Subject: RE: Planning Consultation on M/28/20/DOC

Engineers comments;

The level of detail supplied is currently insufficient to enable the discharge of conditions 11, 13 or 14.

Figure 1
Groundwater Level at all Boreholes

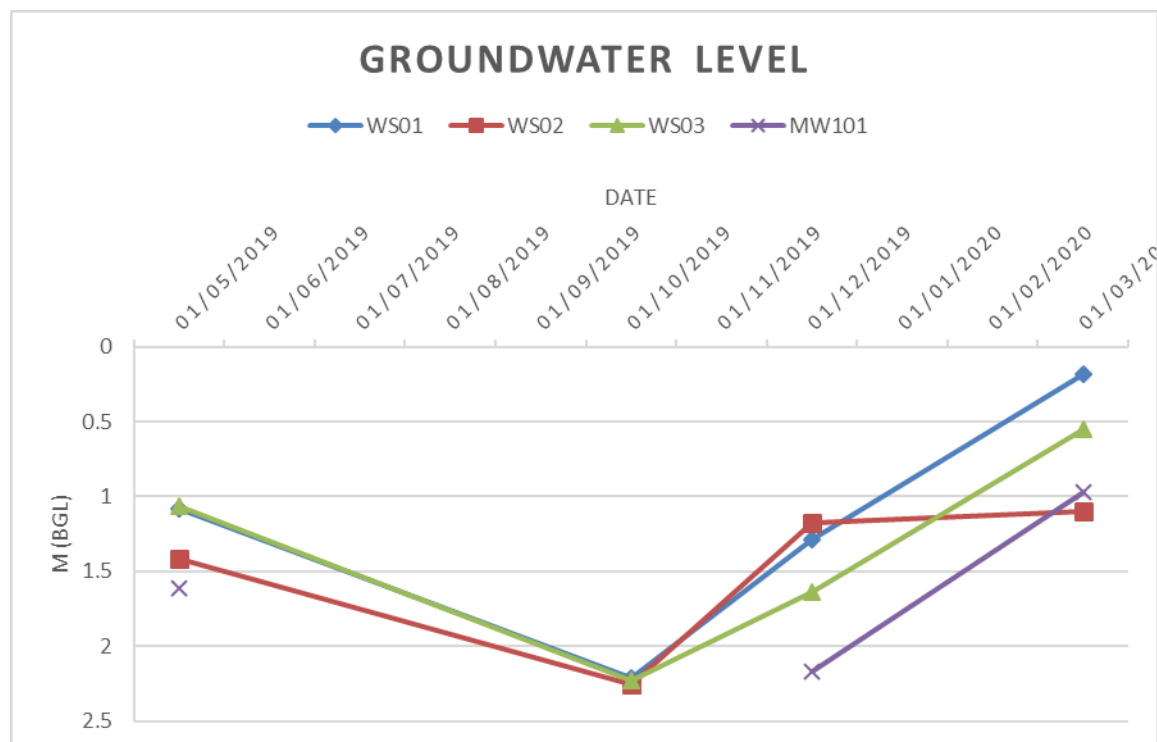
Firstly, we need to be sure that shallow infiltration is not possible, as part of an overall scheme. Please provide a plan showing all the groundwater monitoring point locations and the monitoring results for all, not just WS02. Achieving 1m freeboard between the base of structures and the peak recorded groundwater level is not a requirement in this particular area, so long as the base is above the peak recorded level. This information will dictate as to whether shallow winter infiltration testing will be required.

Figure 4
Route 1 Plan and Section AA'

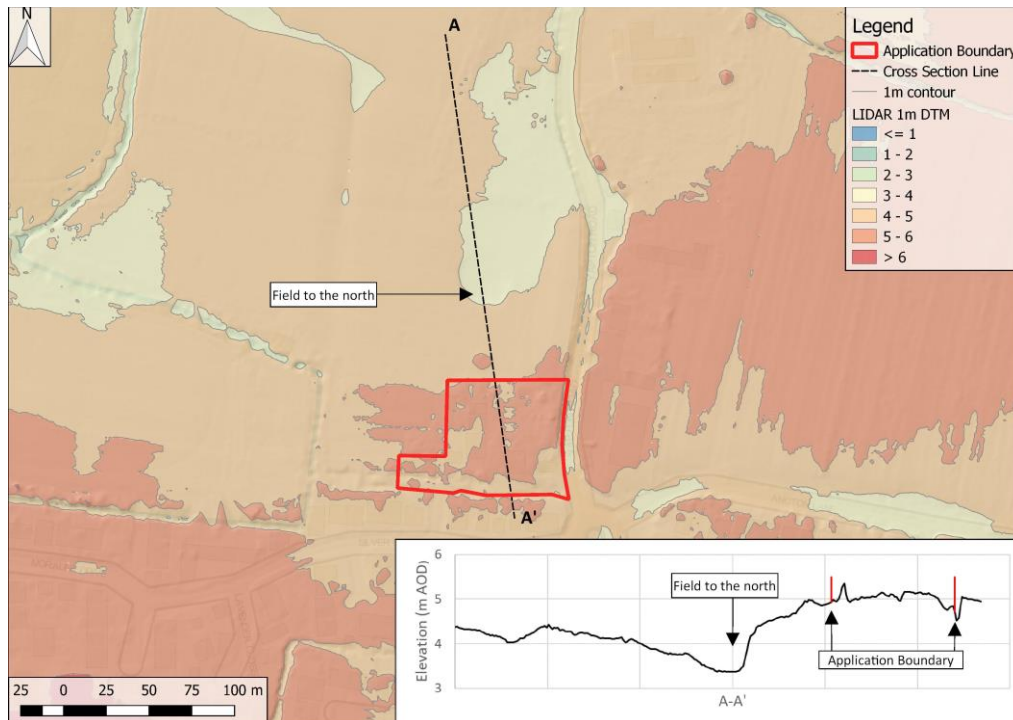
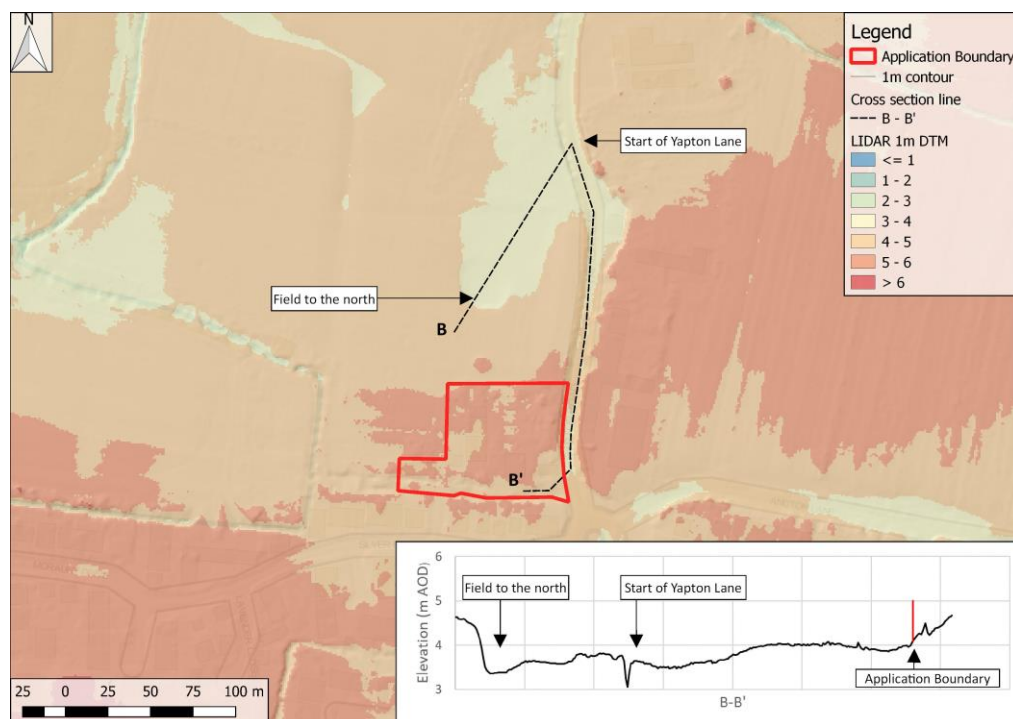
The applicant should also provide topographical evidence to show that no overland/exceedance run off flows from the field to the north will have any detrimental effect on the development/suds.

Site: YAPTON POULTRY FARM
Project: MIDDLETON RESIDENTIAL
Date: 01/07/2020
Drawing: SITE VISIT DISCUSSION
APPENDIX 02

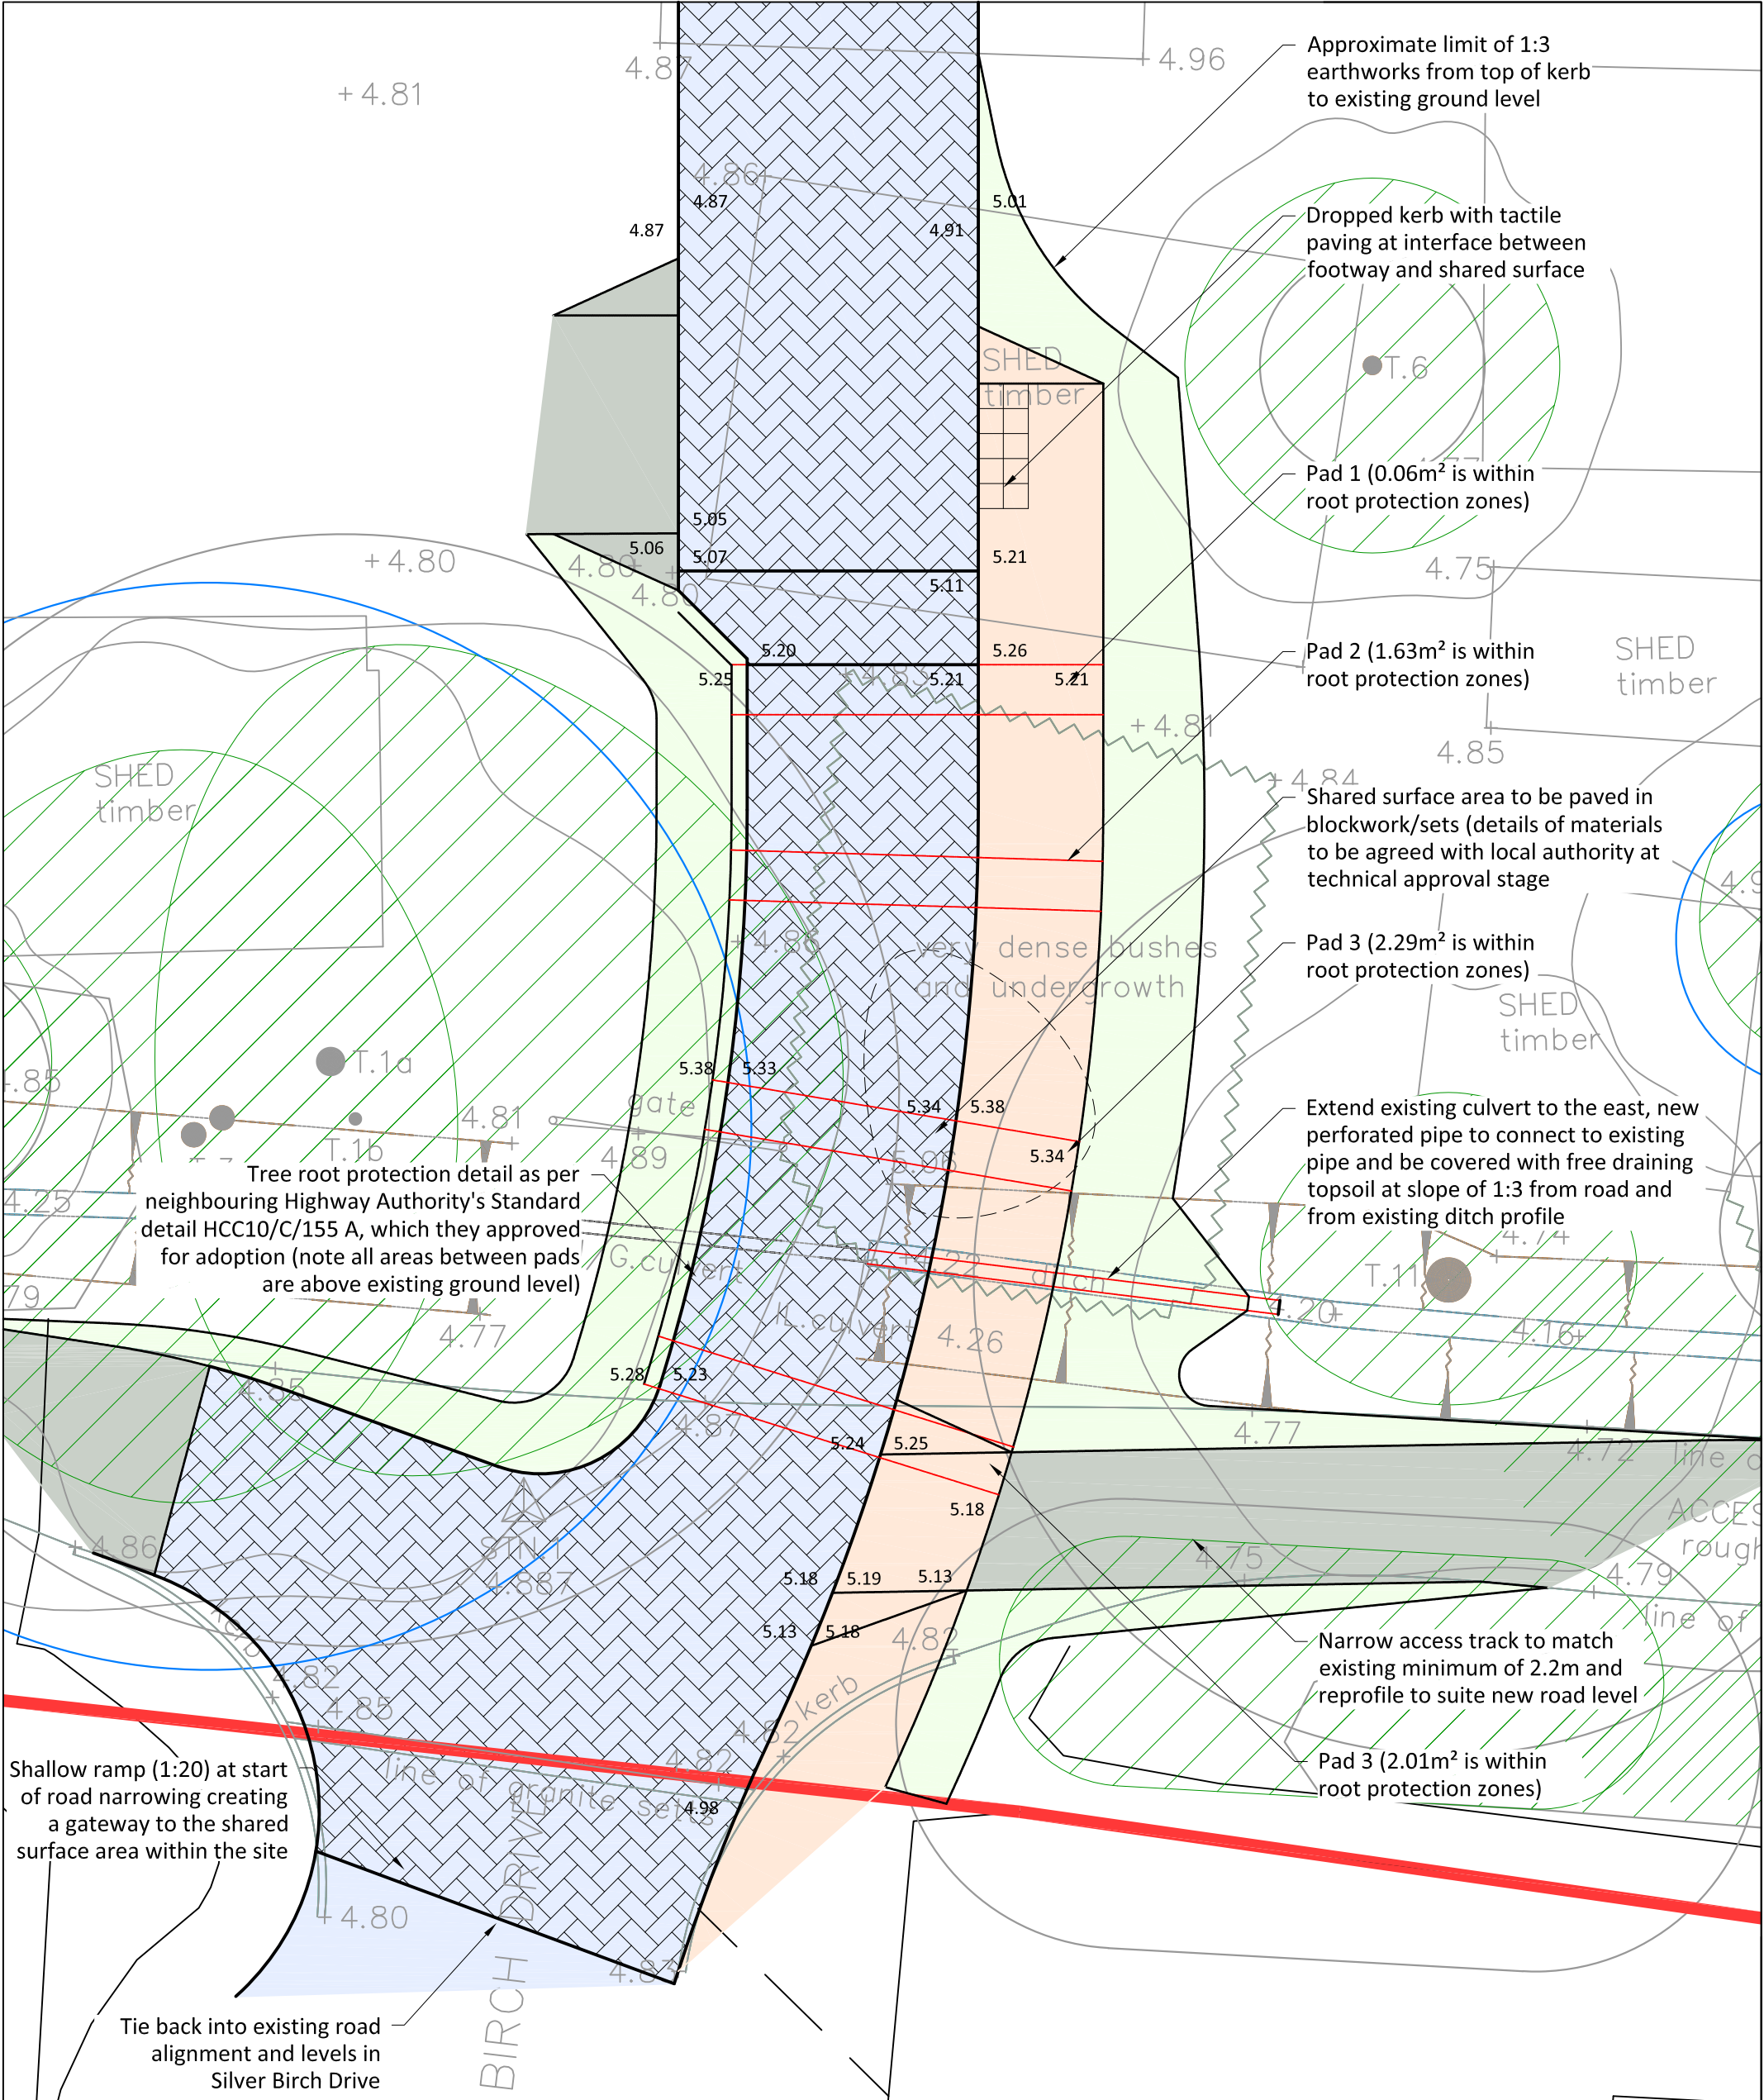
Regarding the ditches on the southern boundary, it is very likely that these will need improvements and I suggest a meeting takes place on site to look at these. Land Drainage Consent will be required for any alterations to them, including culverting and any discharge structures. This will all need to be fully detailed on the drawings.
